Glint and glare effects along Skipwith Road (SDS1)

I am requesting the applicant re-consider REP2-120 Document Reference: EN0110012/APP/LVS/08.20 comment references D-WR-LAN04 and D-WR-GLI-01 given in response to the comments I raised REP1-055.

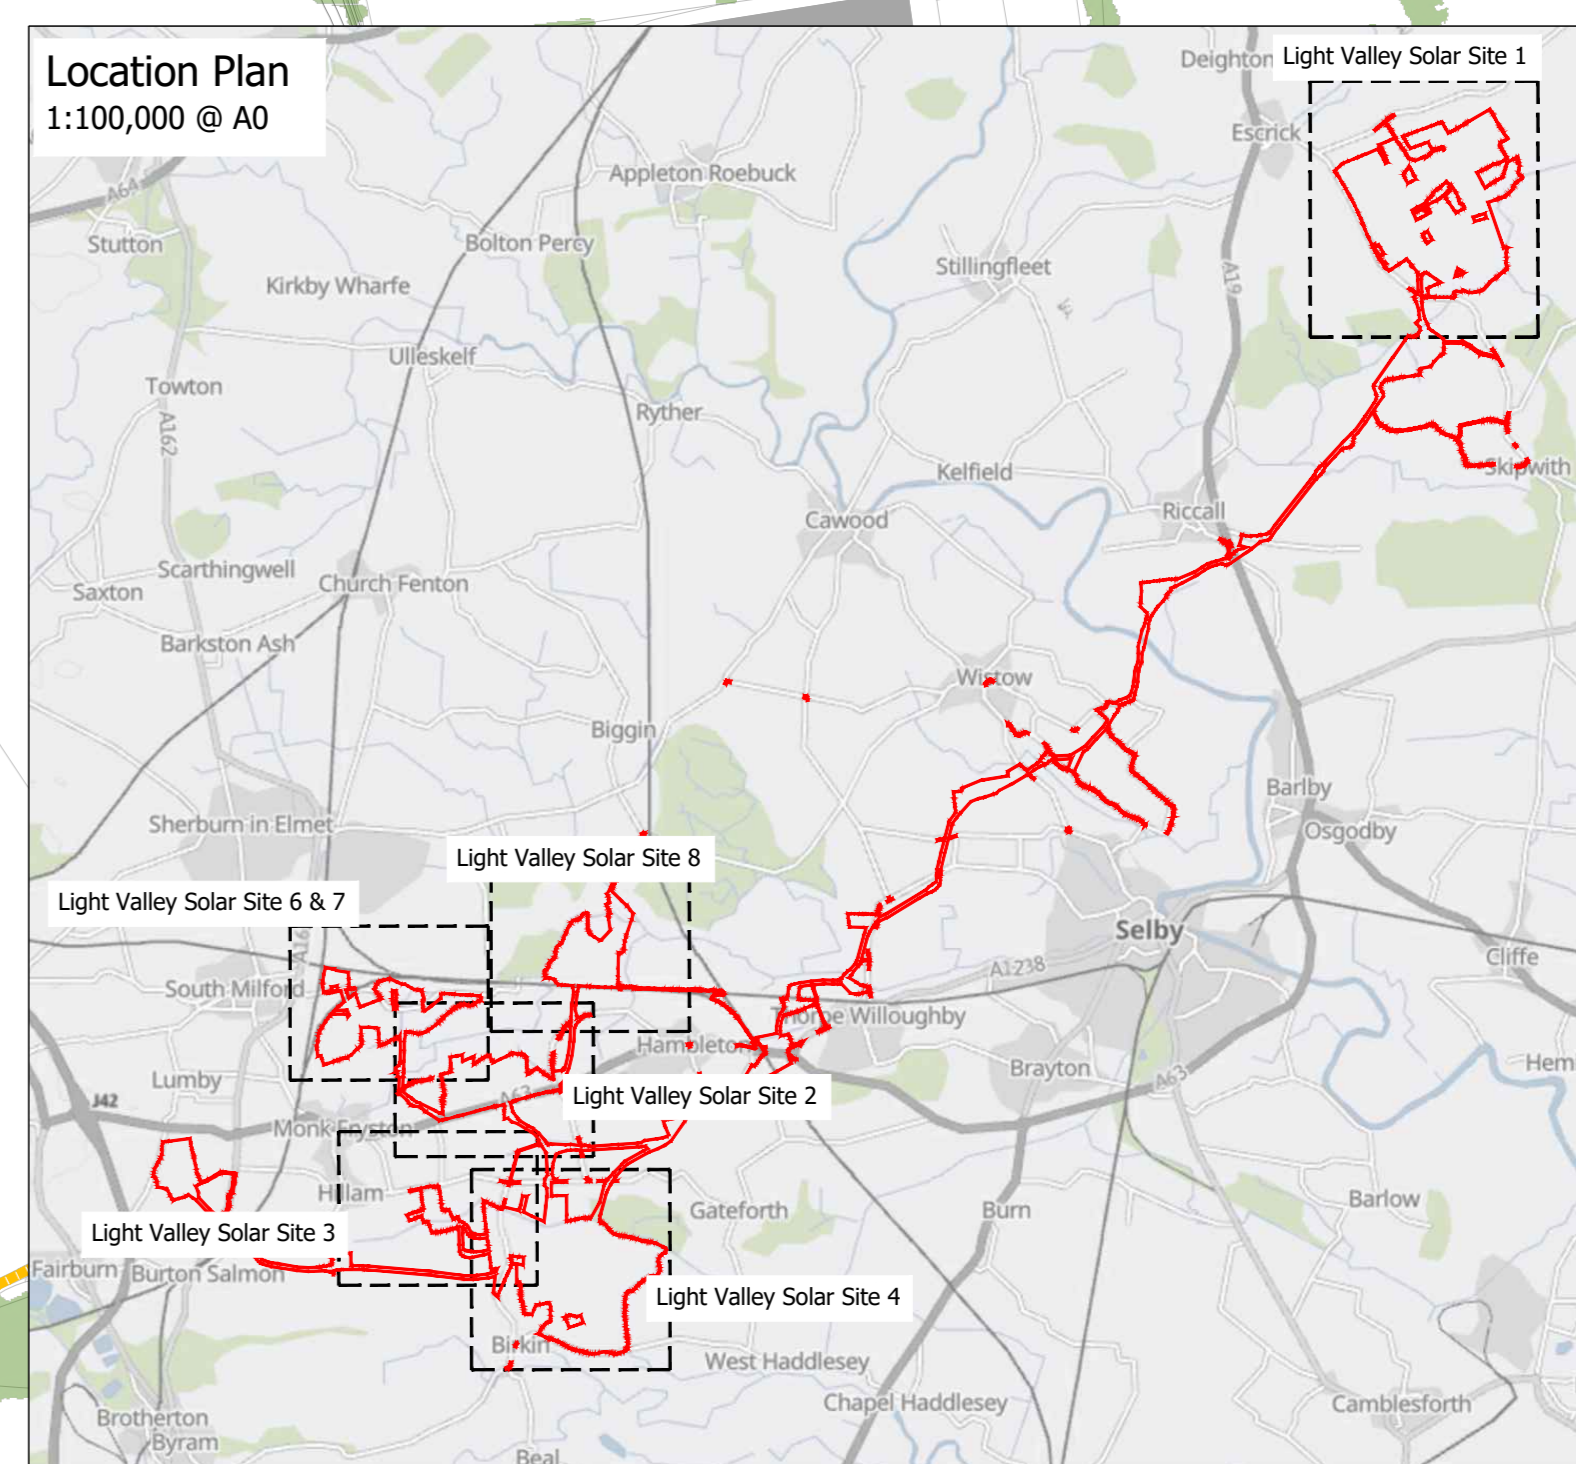
In addition concerning the proposed permissive path for pedestrian and cyclists now shown on 02.12.01 & 02.12.02 Outline Environmental Masterplan Site 1 Sheets 1 and 2 referenced in the response, the impact of glint and glare for cyclists using the permissive path also needs to be considered for significance in terms of safety.
